**Consultation Response from Mike Hibbert,
KC Waste Strategy(Refuse & Recycling)**

2023/91469 2, 4 & 6, Thornton Lodge Road, Thornton Lodge, Huddersfield, HD1 3JQ

Prior notification for change of use from shop/restaurant to 3 dwellings

Responding Ref: WPS 23-027

DWG NO. 2304 - 02

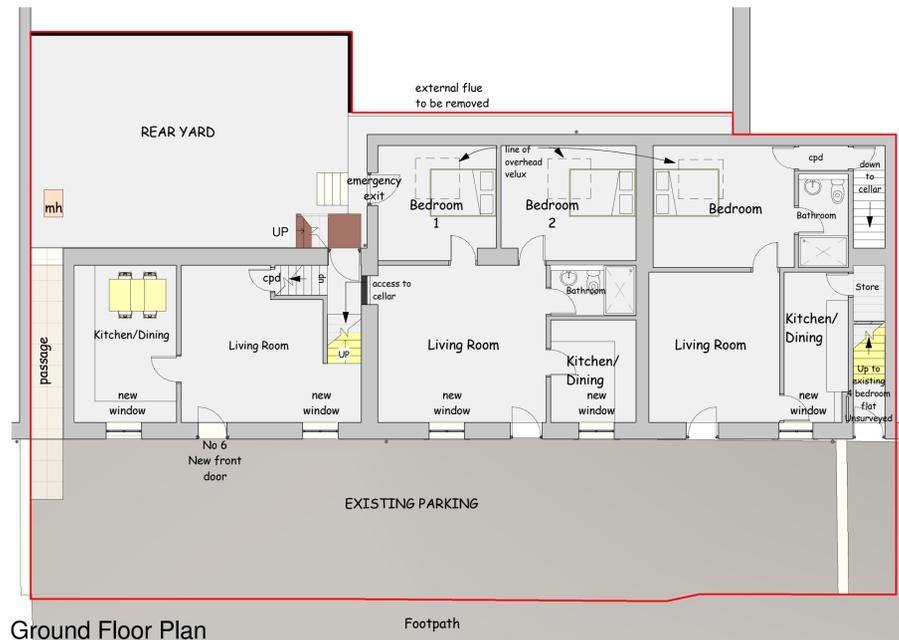
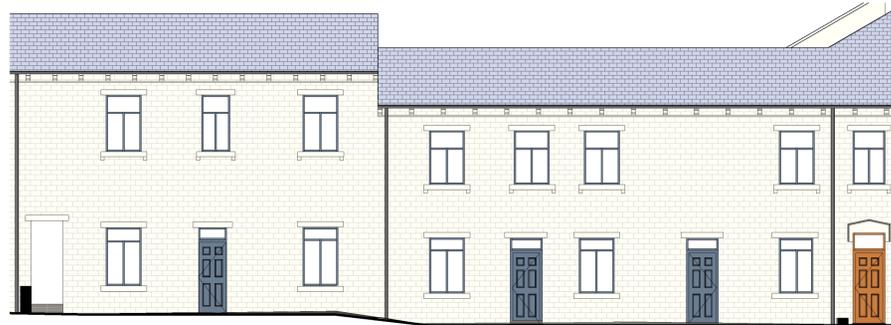
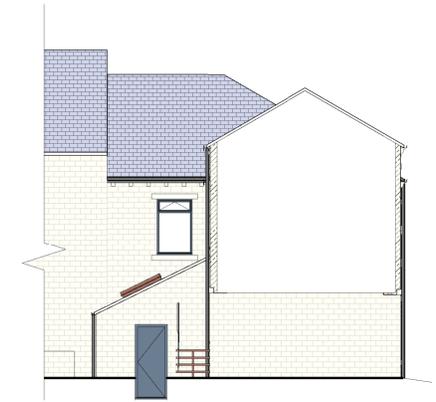
The applicant has submitted Plans, Elevations and Views as Proposed Ref 2304 – 02 dated 5/05/2023 that show the conversion from a takeaway and shop back to original use as three dwellings.

- The proposed development would require provision of a waste storage area for 2 x 240ltr bins (1 for general waste and 1 for recyclable waste) for each dwelling or a communal bin to service the three dwellings (180ltrs x3) so two 660 ltrs bins The storage area should be on hard, smooth, level surfaces that can be easily cleaned and drained and with access to Thornton Lodge Road avoiding steps or steep gradients. The alleyway to the rear yard on the plan appears to be 900mm wide that should be sufficient width to allow a 240ltr wheelie bin to pass through.

- Storage of bins on the pavement on Thornton Lodge Road would be unacceptable. Preference is given to storage at the rear of properties. Wheeliebins should be stored at the rear of the property with the resident's presenting bins on Thornton Lodge Road on collection day at a Bin Collection Point (BCP). If this is unviable or access through the alleyway to the rear is not practicable with a wheeliebin, storage maybe required to the front of the properties.

- Additional information is required including a location plan showing bin storage and presentation point locations. If storage is to the rear of the premises, confirmation there is access between the storage area and presentation point. Design specification for a store/ screen if required and number/ configuration of wheeliebins.
